Application for a Non-Material Amendment Following a Grant of Planning Permission

Erect One Dwelling, Barn Conversion to form a Second Dwelling and Demolition of Existing Barns

20/00078/FUL

Removal of door & window on Gable end of single storey element.

Client	Miss S. Williams-Ellis		
Project	New Dwelling & Barn Conversion, Sturton Le Steeple		
Title	Proposed Elevations House Type A & B		
Drawing No.	EL01	Rev.	P07
Scale @ A2	1:100	Date	Nov 19

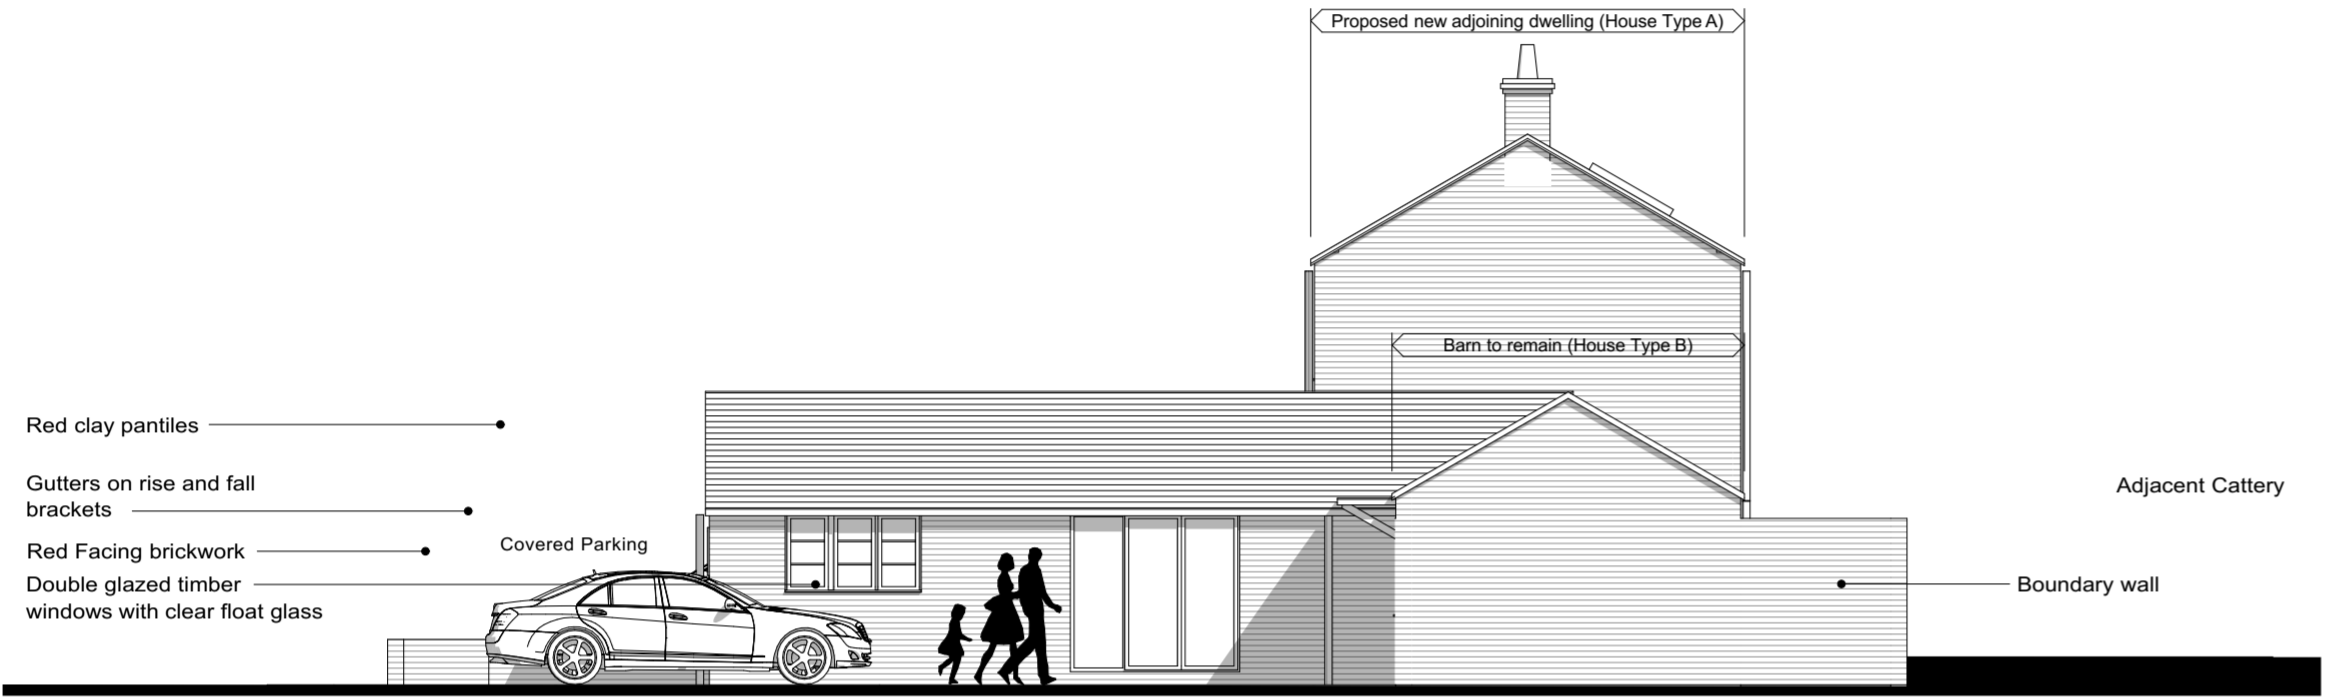
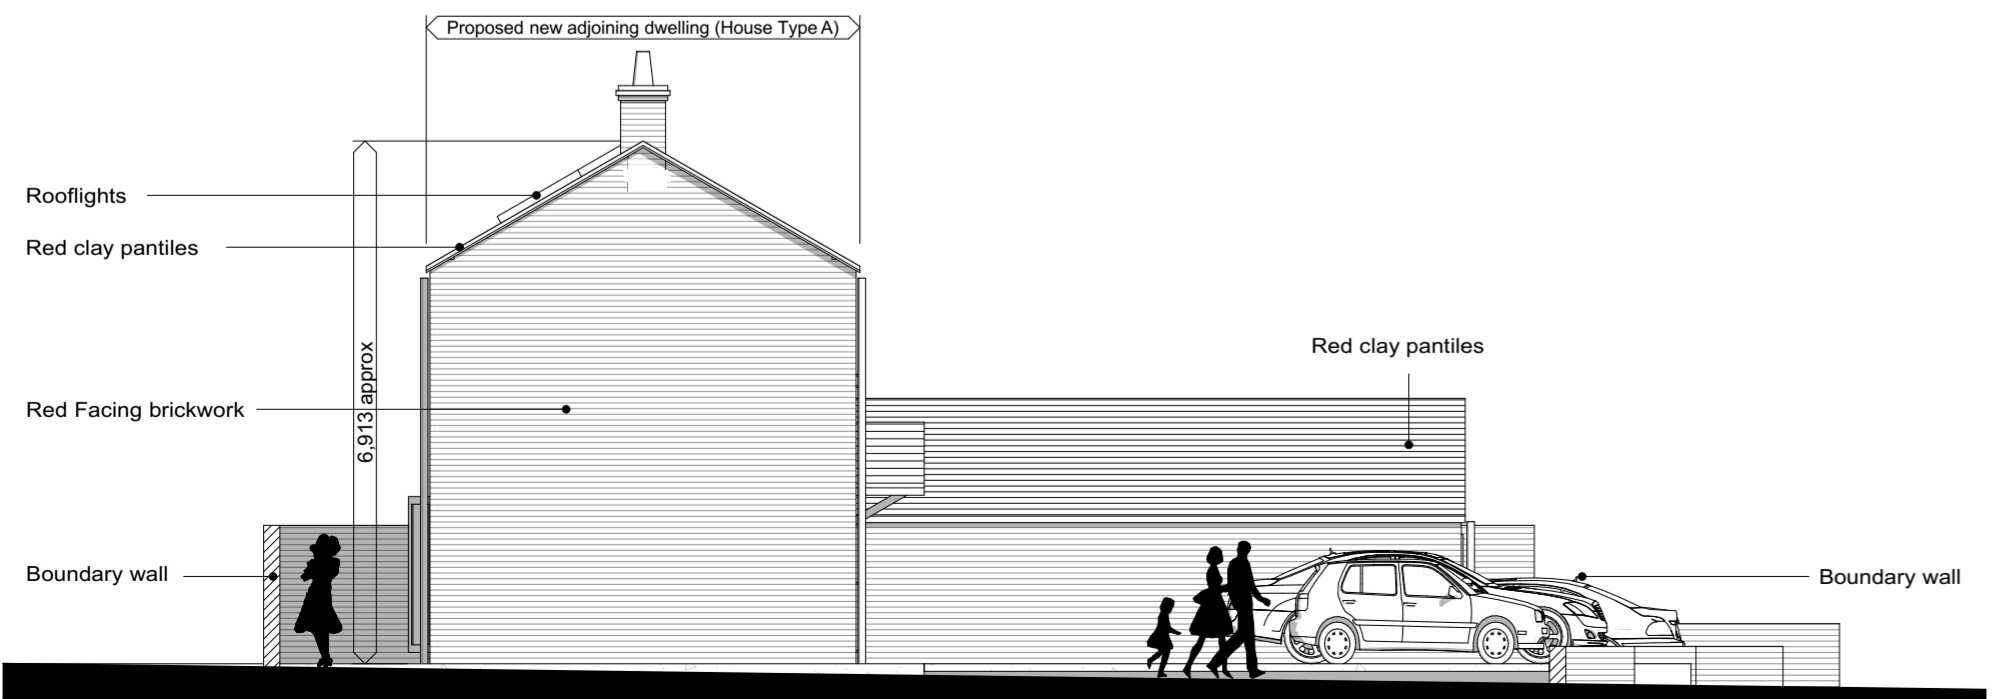
The addition of a personnel door to the gable end of a period style property is at odds with agricultural design style of the period. In addition it is restrictive to the kitchen layout and not needed due to having 2 other entrances.
